December 5, 2017

Owner / Applicant

George Cusic & Pamela Cusic
10260 Peaceful Valley Rd.
Colorado Springs, CO 80925
719-491-1261

We are located at 10260 Peaceful Valley Rd., Colorado Springs, CO 80925. Our property is 10 acres, zoned A-5, Single Family Residence. We are requesting a Rural Home Occupation Special Use Permit to allow us to store and park equipment, use pole barn for equipment storage and maintenance. We employ 5 to 8 employees not counting ourselves. Our office is in our home at the front of the property. We do not conduct any business out of our shop, employees arrive and leave returning at end of day. Occasional we stock pile left over hot mix at end of day or waste asphalt from jobs at our site but frequently load and haul of to be recycled.

10260 Peaceful Valley Rd.

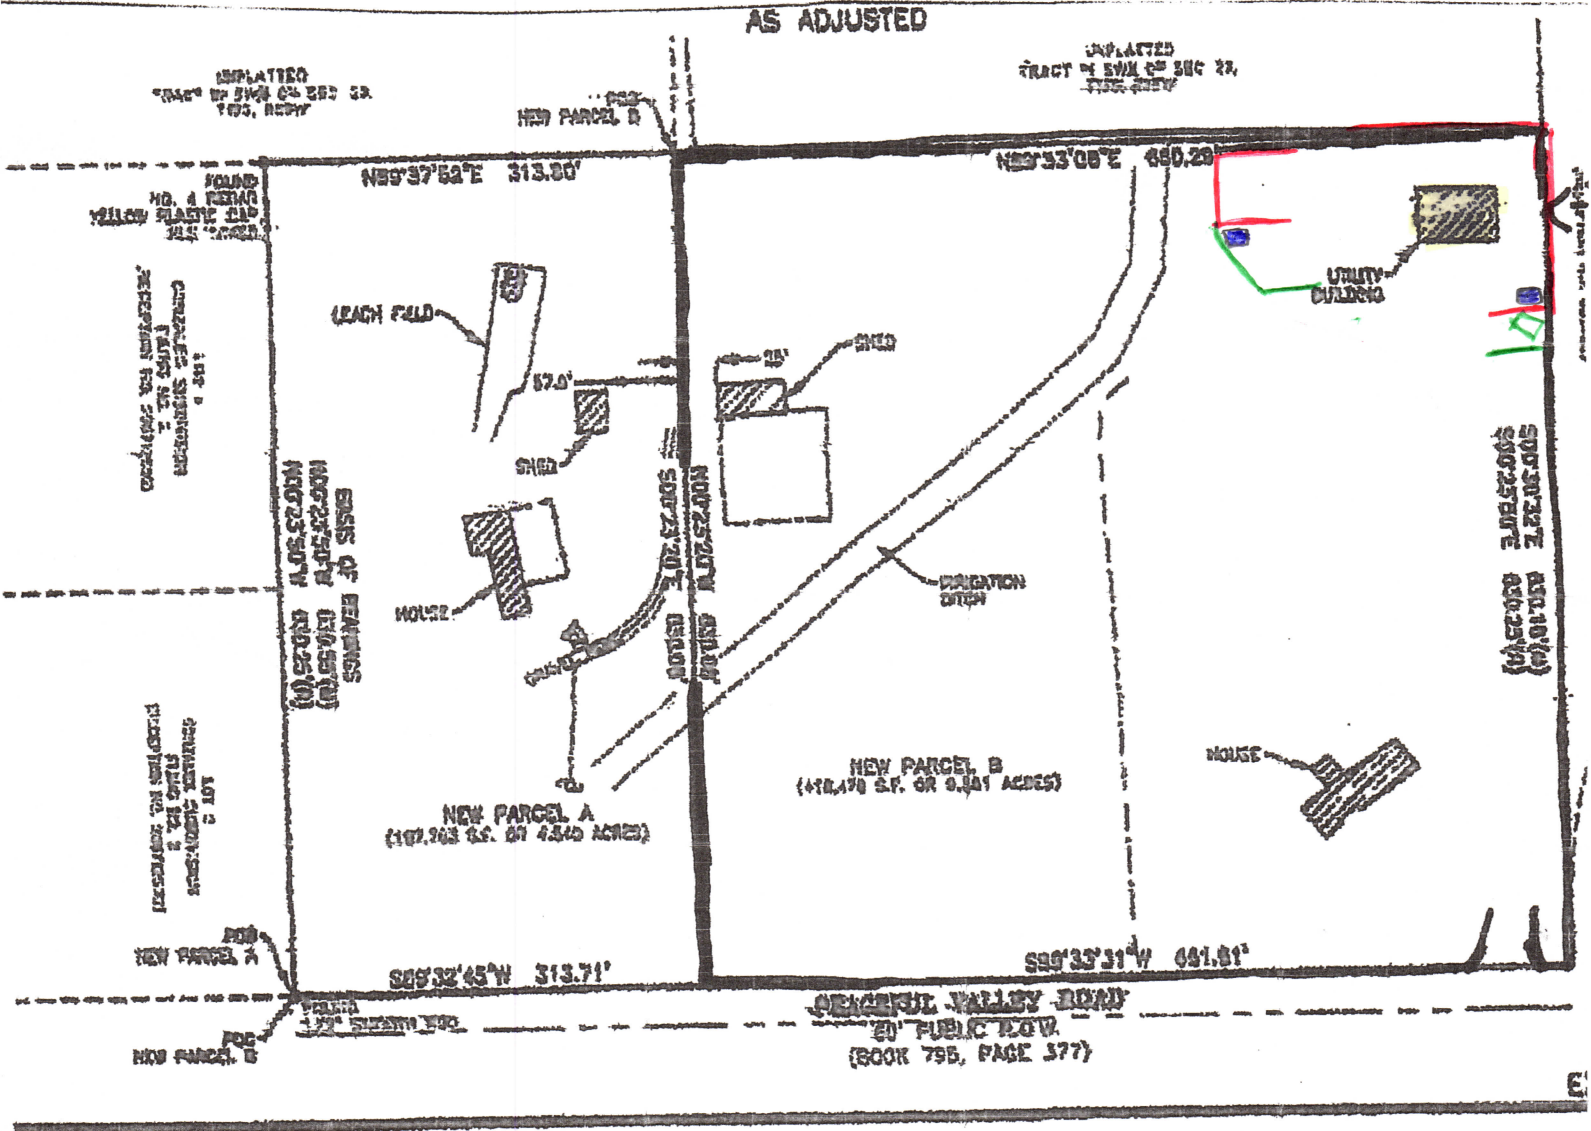
Please state that you do not intend to add any additional structures at this time, therefore no change in drainage is anticipated over what has been existing there since the shed was constructed in 2000. An access permit is required to legalize your point of access.

Please add a statement about the anticipated vehicle trips, and confirm that the business will not add more than 100 trips per day to the residential use (note that one person coming and then going in the morning is two trips, so if you have an employee come to the site in a personal car, leave to go to the job in a work truck then return and swap back to a personal car then leave to go home, that is 4 trips). Please feel free to call me with questions. E. Nijkamp
